WRITTEN REPRESENTATION

Doc 6.1 para 8.292 – confirms adverse effects on Stoney Stanton, but the mitigation below will not lessen these.

Doc 6.1, paras 8.317 – 8.328 - Highways Improvements

M69-A47 LINK ROAD GENERAL ARRANGEMENT

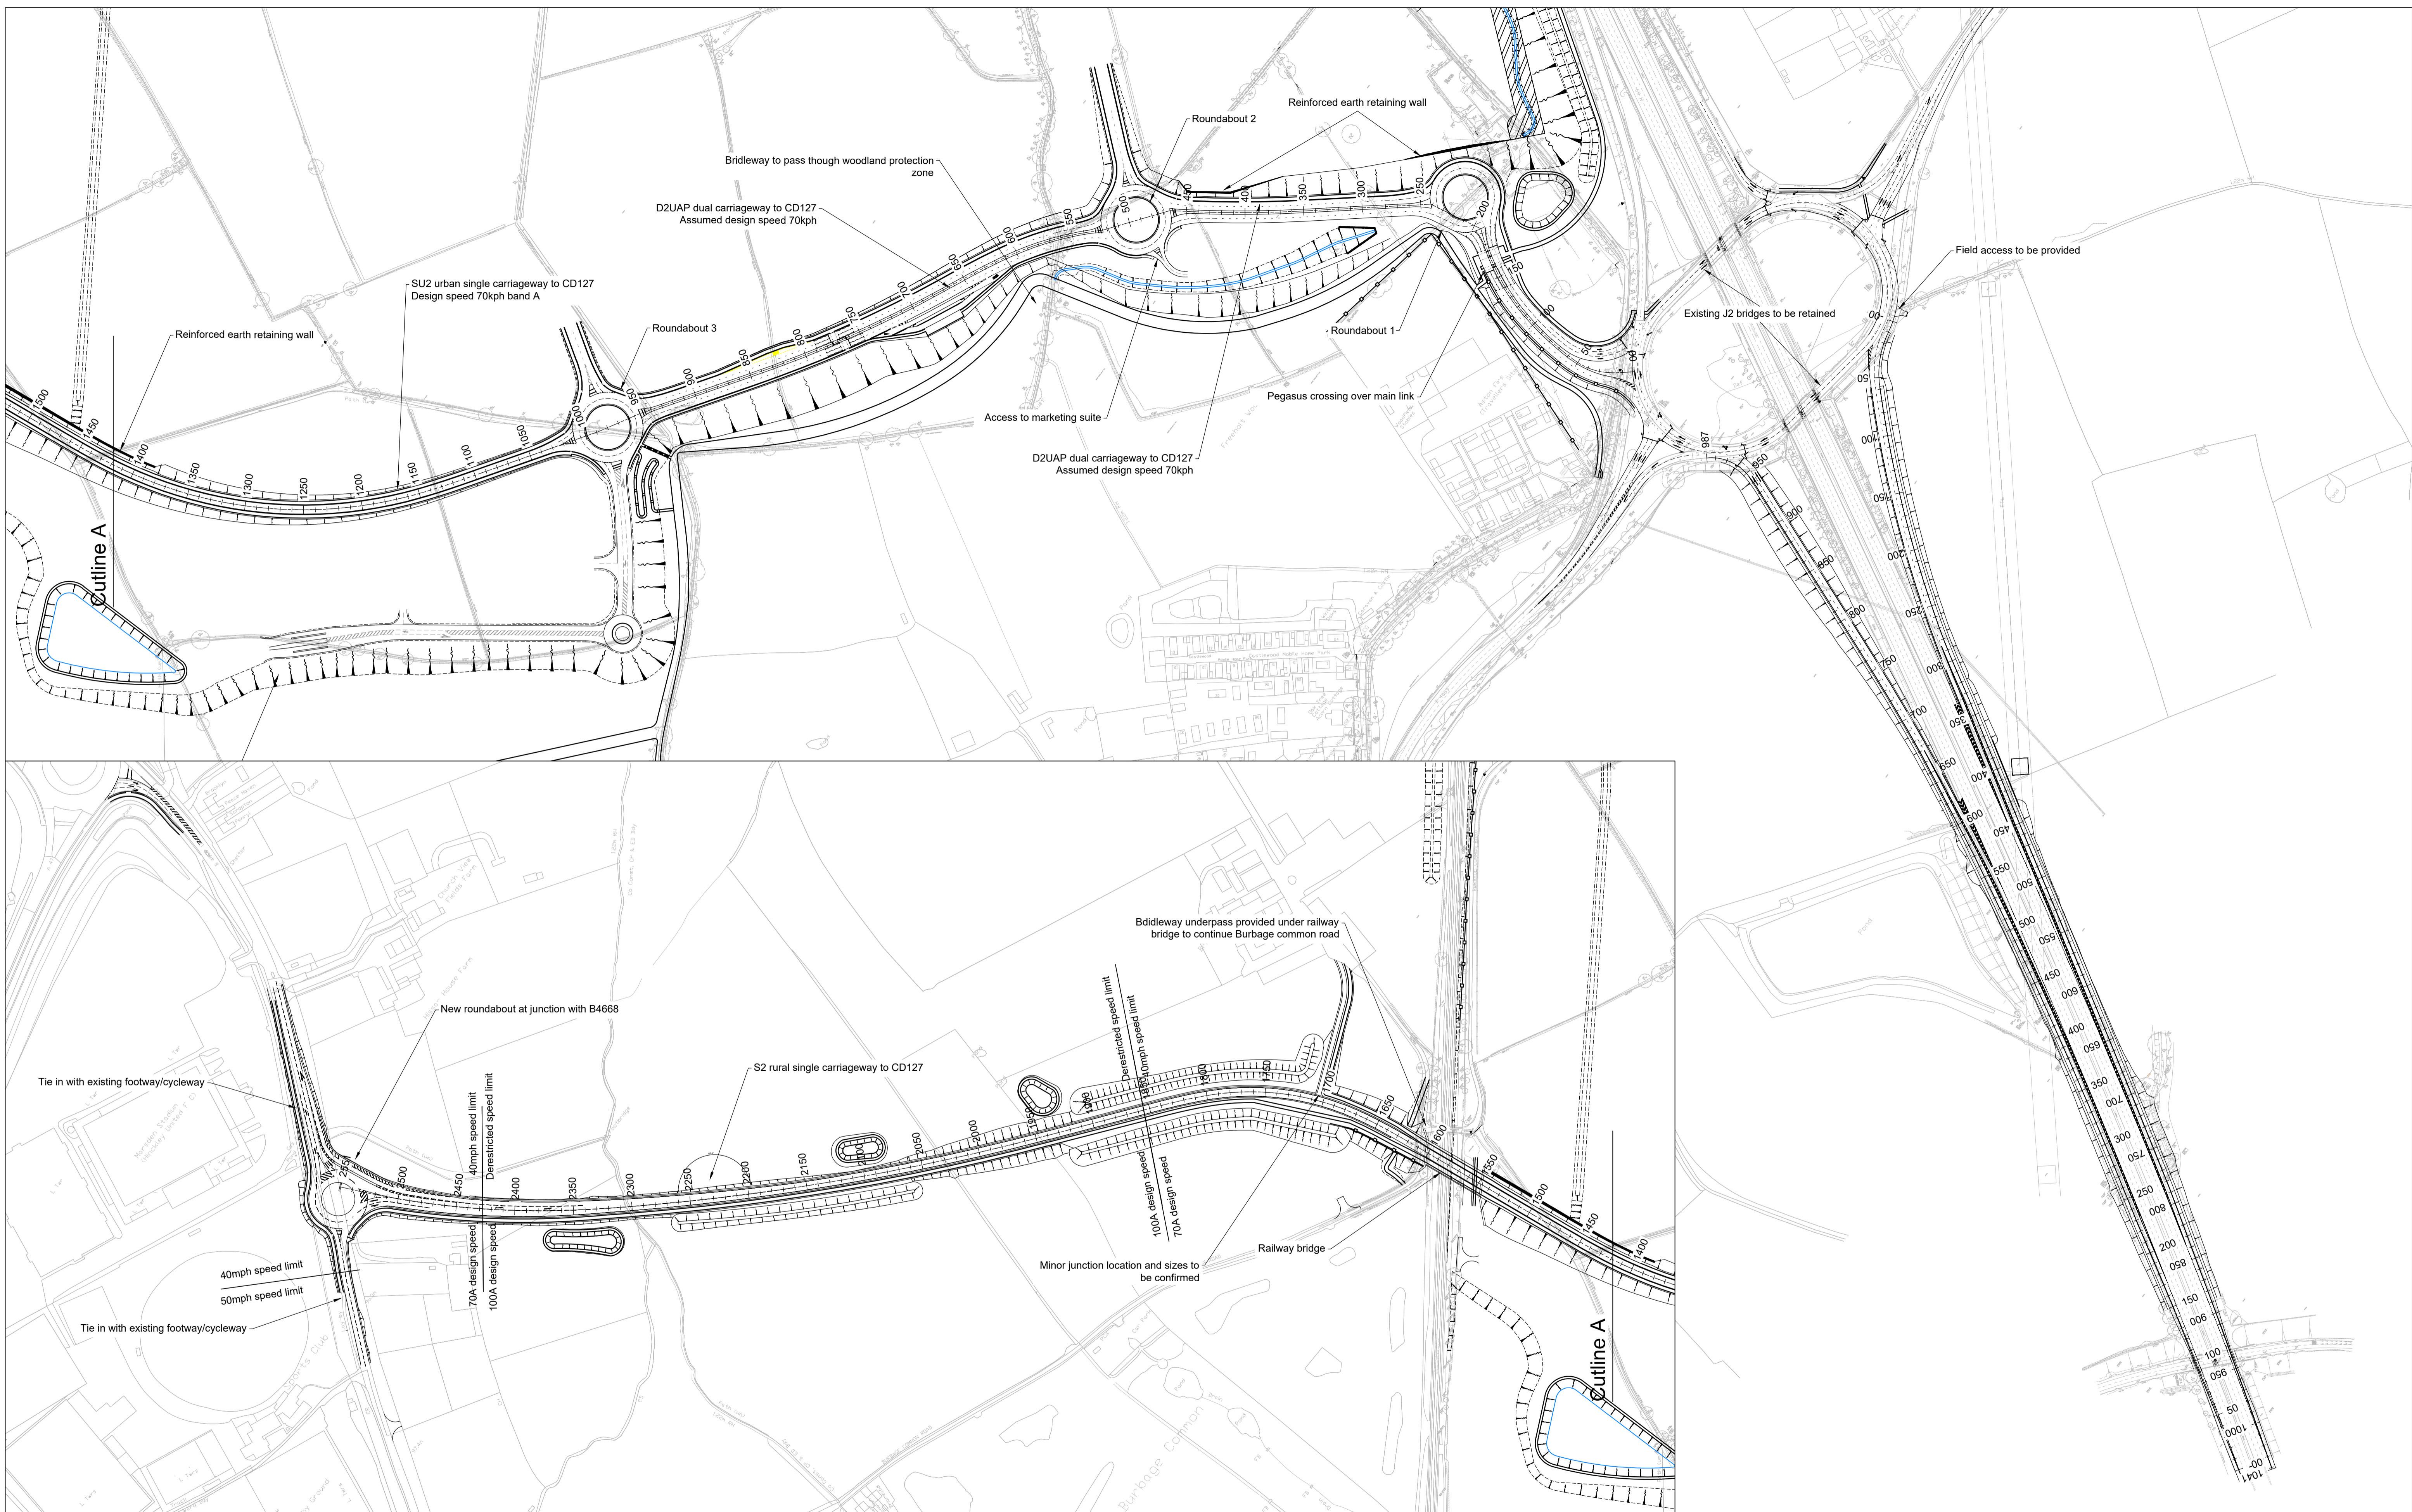
New A47 Link-road between B4668 Leicester Road, the HNRFI Site and the M69 Junction 2 with access for all general traffic.

With the use of a B road, to link to a single carriageway A47 road, this will slow traffic down and become very busy.
